PLANNING AND COMMUNITY DEVELOPMENT
 CRAIG DOSSEY, EXECUTIVE DIRECTOR

Subject: Academy Village Filing No. 3 Vacation and Replat- Review 2

FINAL PLAT
ACADEMY VILLAGE FILING NO. 3

Re: **Planning and Community Development Review of VR-17-01 – Academy Village, Filing No. 3, Second Submittal – Comment Response**

ACADEMY VILLAGE FILING NO. 3  
UTILITY SERVICE PLAN

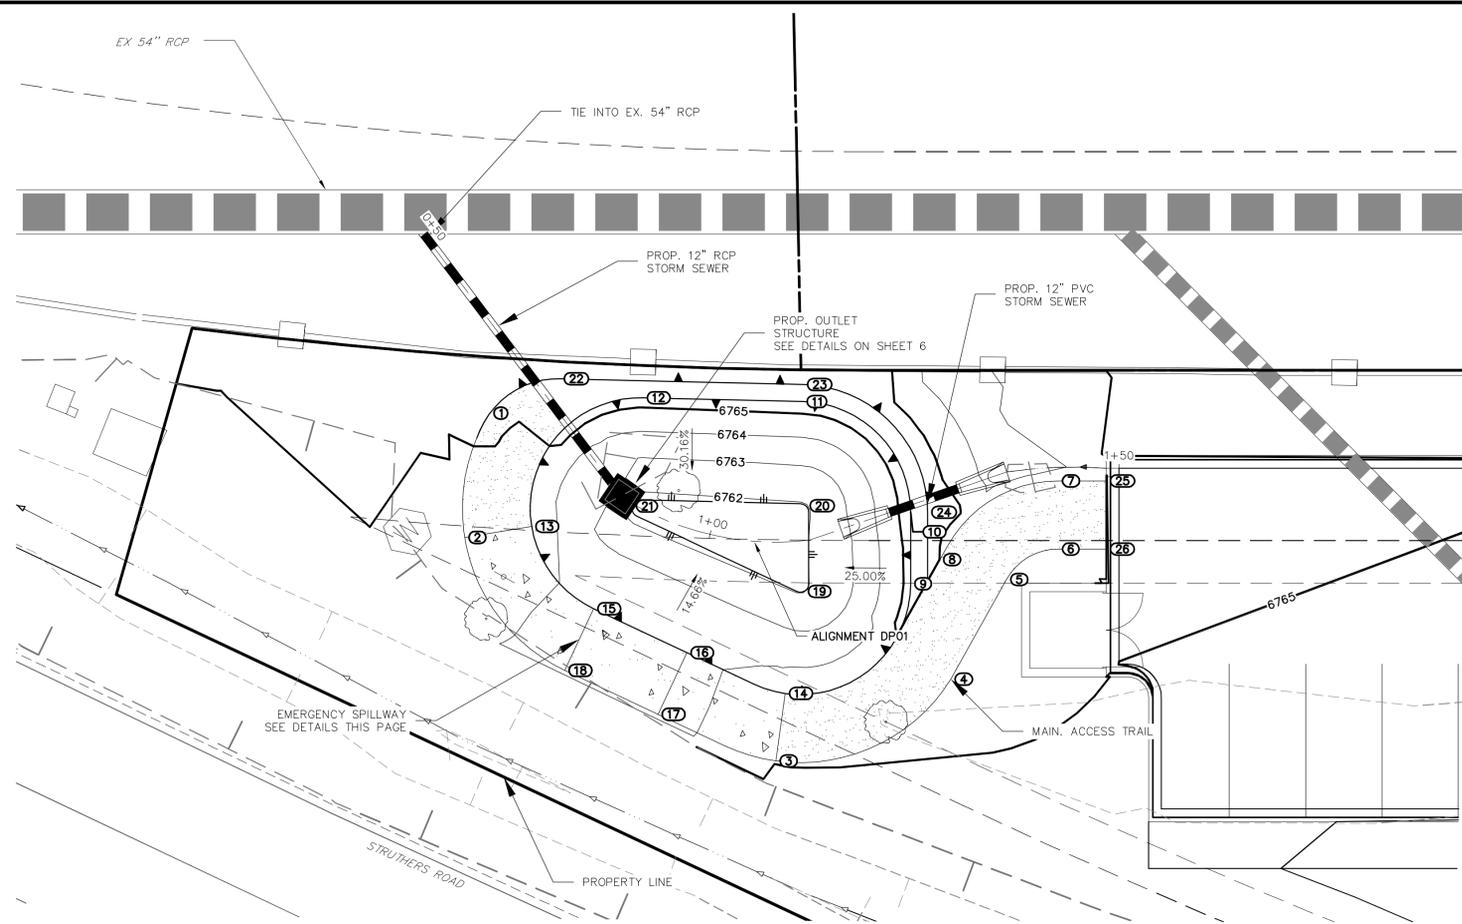
1. Note: the Site Development Plans were used for reference, but not reviewed as construction plans for this plat since there are no public improvements.
2. Provide a separate set of utility construction plans for the utilities crossing Struthers Road, including profiles, details, etc., and the utility district's signatures. Note: approval of these plans will allow for issuance of a work-in-the-right-of-way permit (with separate fee) from EPC Department of Public Works. **Partially resolved; see redlines.**
JR Response: Addressed. A separate utility services plan has been added.

ACADEMY VILLAGE FILING NO. 3
 POND GRADING PLAN

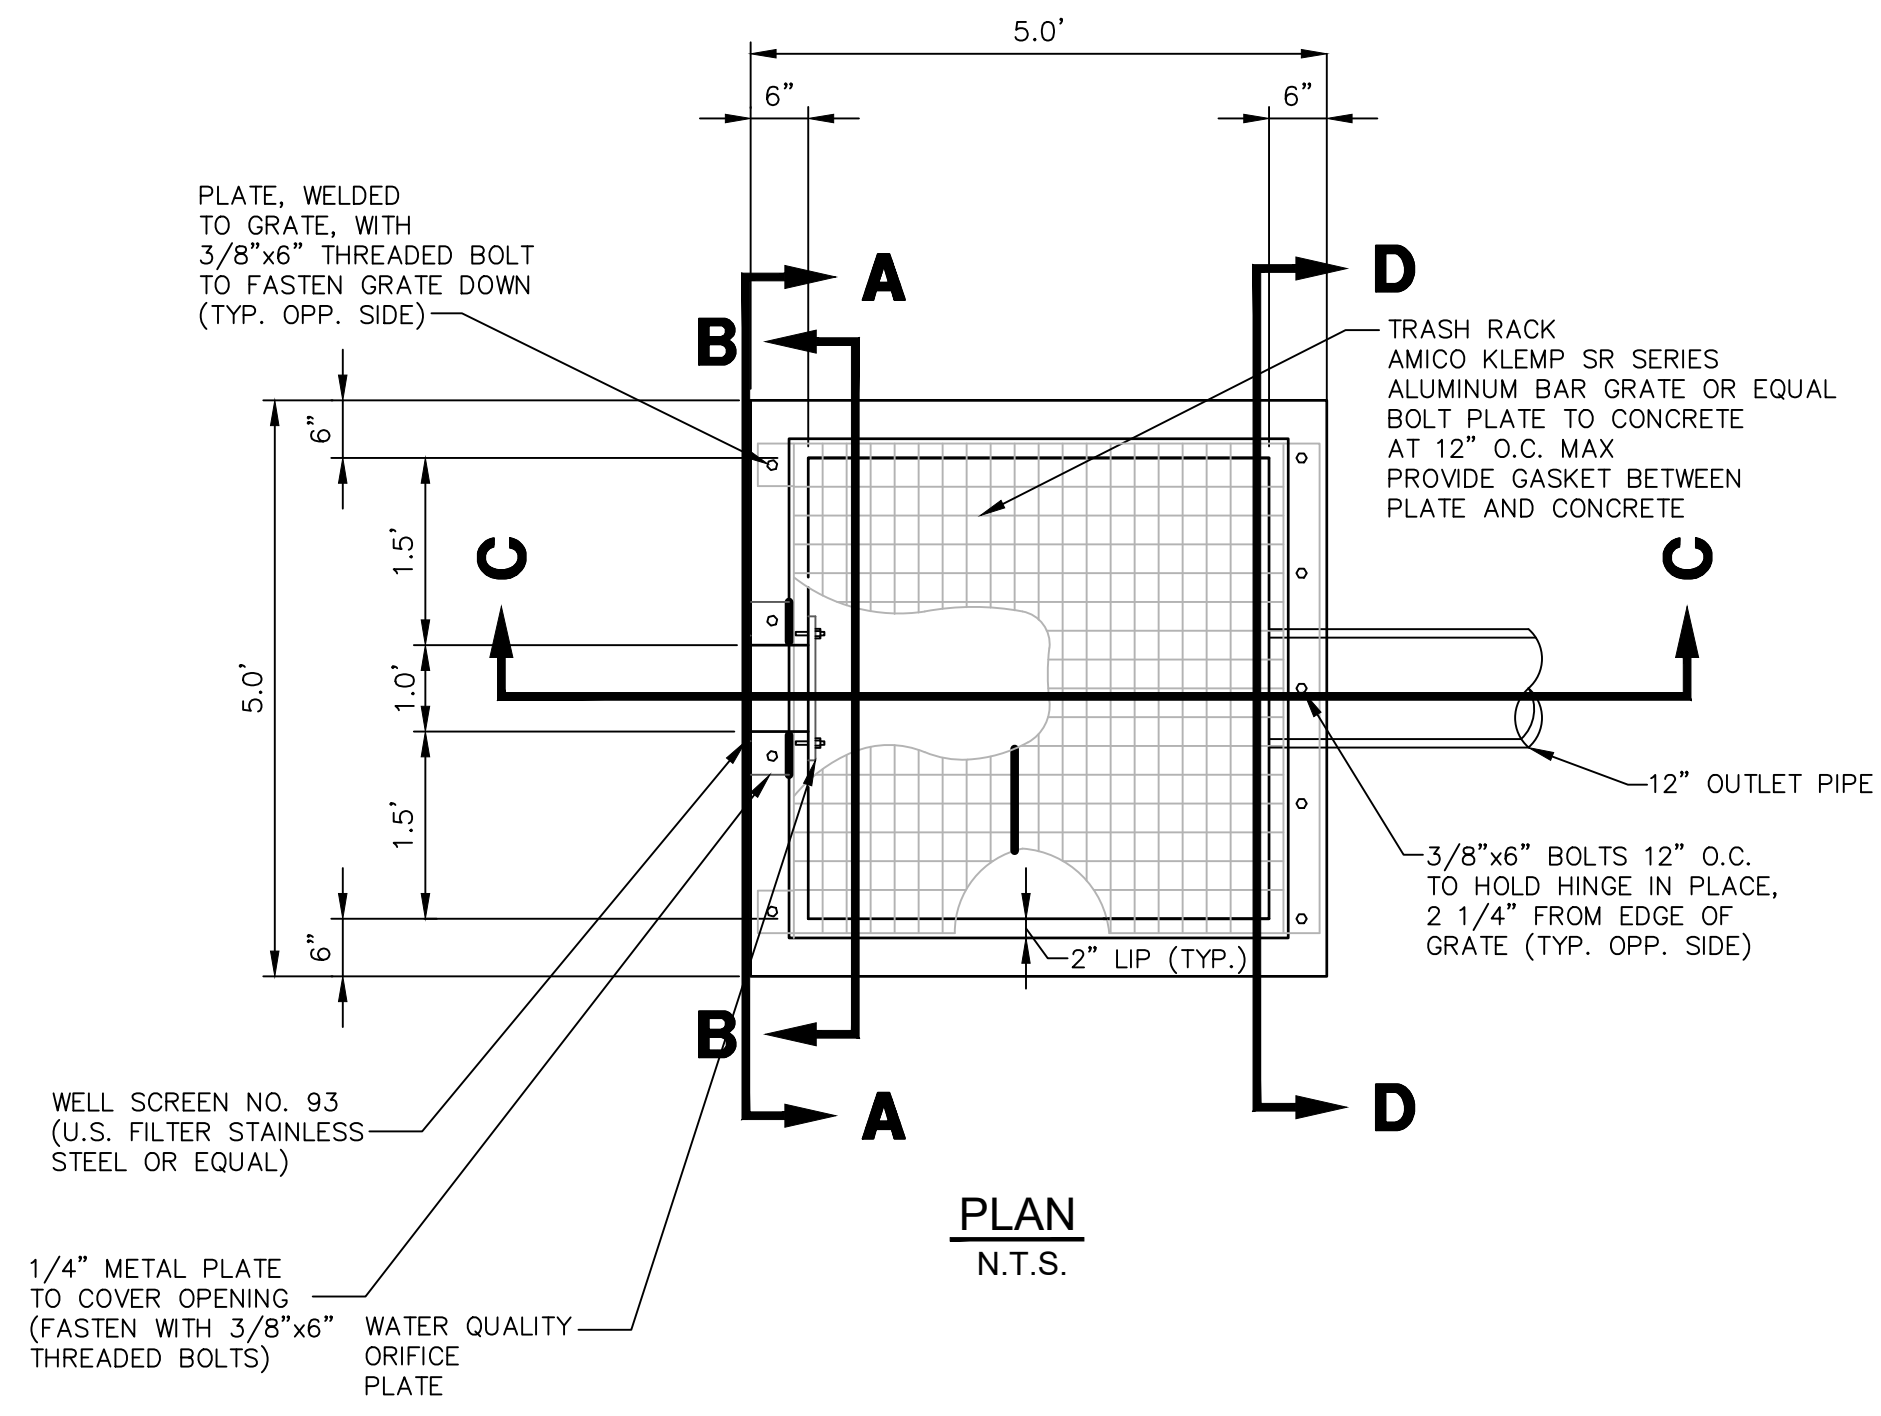
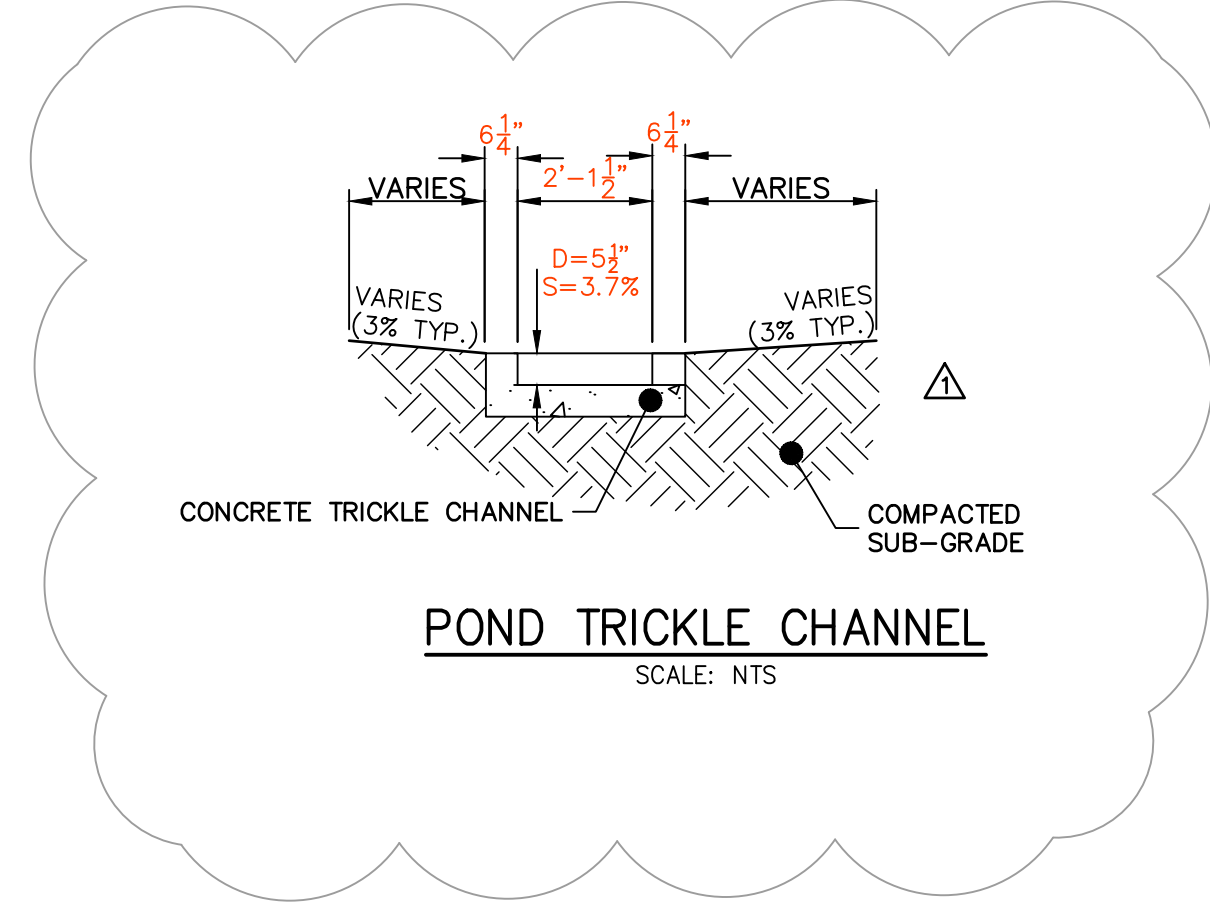
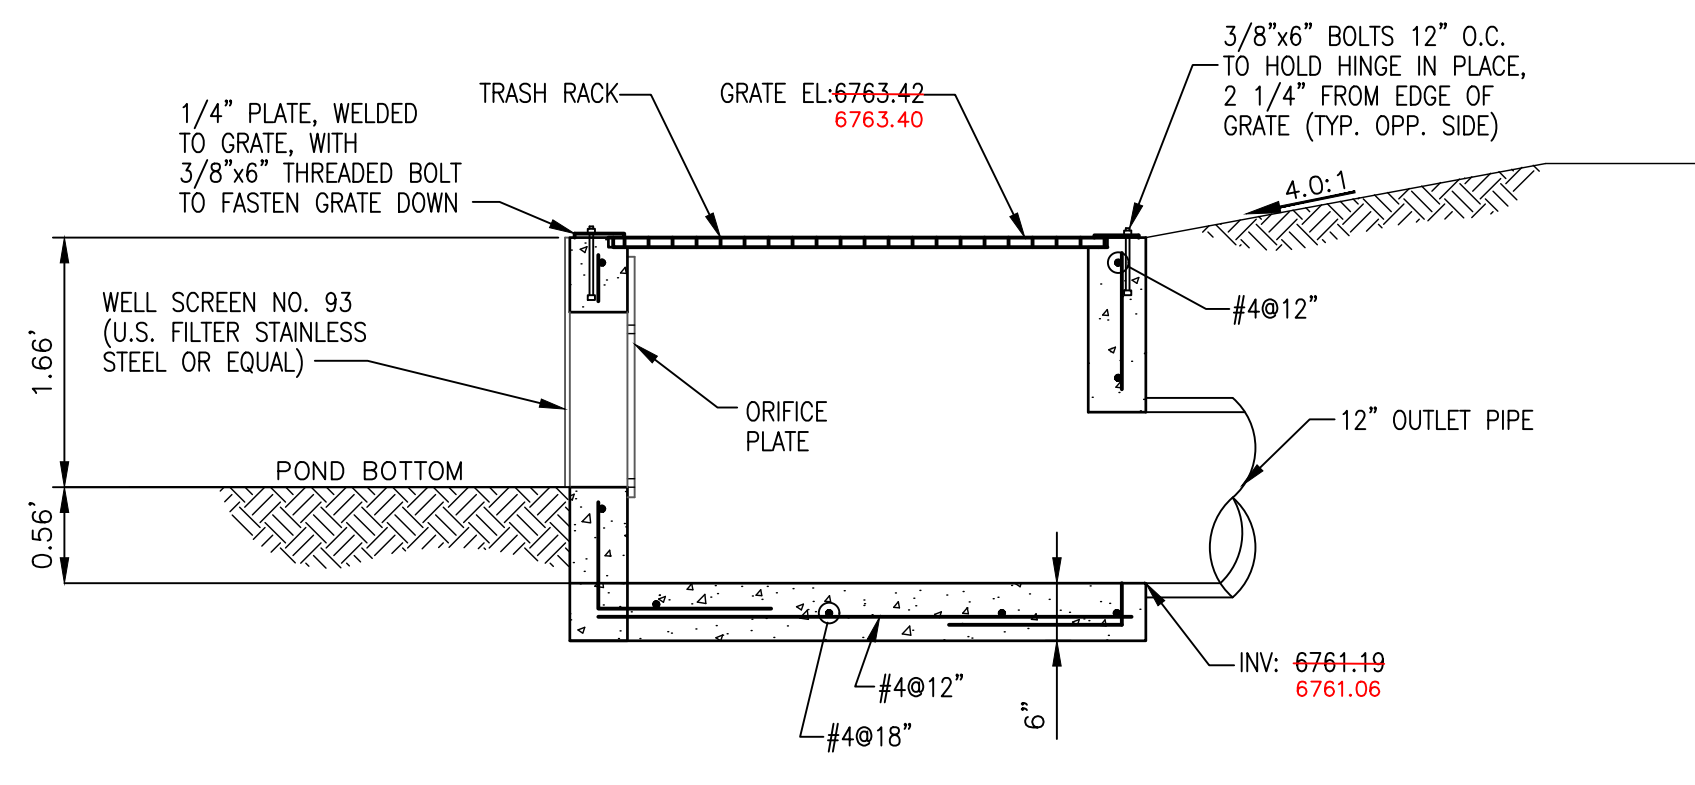
3. Provide complete WQCV pond design including emergency overflow path. **Unresolved (see comment #2).**
JR Response: WQ pond information is included in the report appendices. Emergency overflow details are explained in the report text. The emergency spillway is called out on the drainage map. Additional pond details will be provided in the construction documents.
4. Address drainage basin and bridge fees. **Partially resolved; see redlines showing calculation of fee per impervious acre.**
JR Response: Basin fees corrected.
5. See electronic redlines for clarification of these comments and additional comments. **See updated redlines.**
JR Response: Comments on report have been addressed.
